Submission ID: [REDACTED]

Subject: Re: Easton Lane - Solar Farm - Feedback on Green Hills Solar Farm Proposal

GREEN HILL SOLAR FARM LTD
 GREEN HILL SOLAR FARM
 GREEN HILL
 CARAVAN ROUTE, ROAD 22
 GENERAL ARRANGEMENT & VEHICLE TRACKING

Title:
Figure 13.15: Access Locations for Sites and
Cable Route Corridor (South Area Part 1)

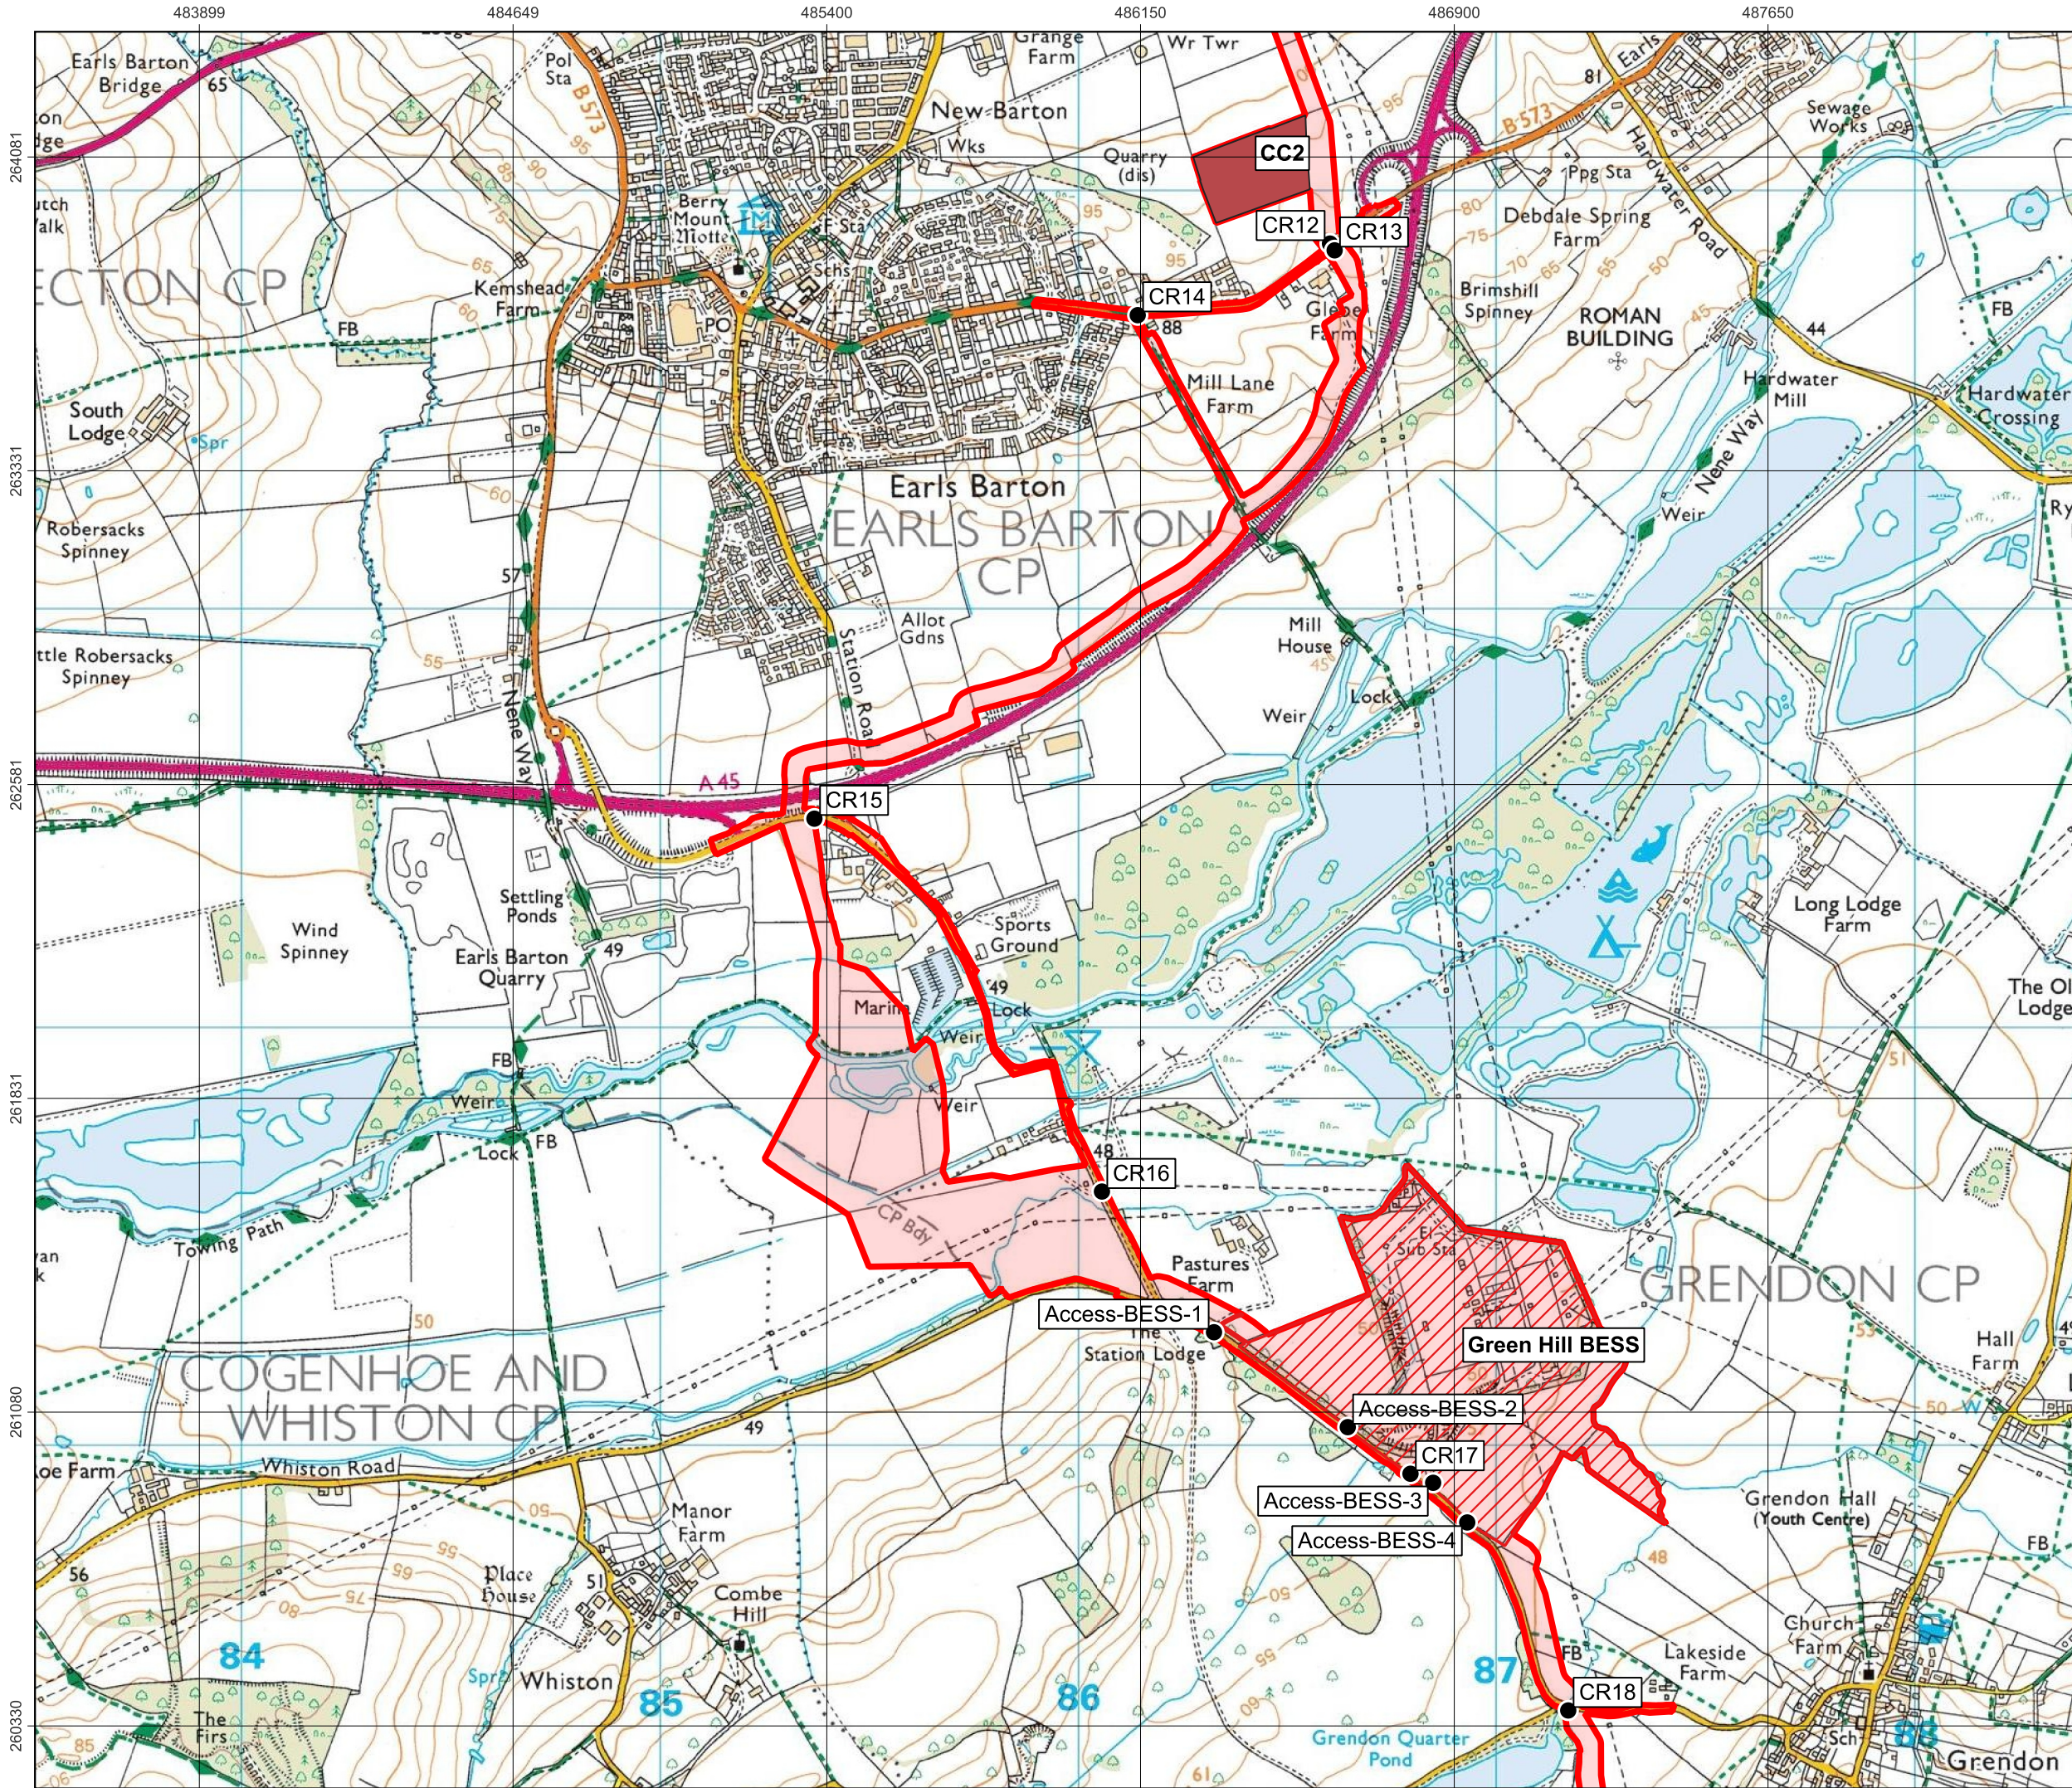
The access point at CR23 is located on a national speed limit road and sits on a sharp bend along with Access-F-2, making it inherently unsafe for HGV movements. Introducing heavy goods vehicles at this location presents a serious risk to road users, residents, and construction staff.

Whether HGVs are now definitively proposed to use CR23 & Access-F-2?

What safety assessments have been carried out specifically for these access points?

The latest drawing of CR23 is attached to this email. We do not propose widening/ changing the access, but instead extend its use to provide flexibility for workers to access this area.

The draft DCO might allow such changes, noting that this drawing is only indicative at this stage.

The use of the existing field access at location CR23 from Easton Lane is proposed to facilitate the construction of the cable connection corridor in this area. The duration of use of the access in this location is not yet known, but will be within the overall construction period and utilised to construct the section of cable connection in this area only.

The existing access will be retained as a permanent access to maintain its existing function.
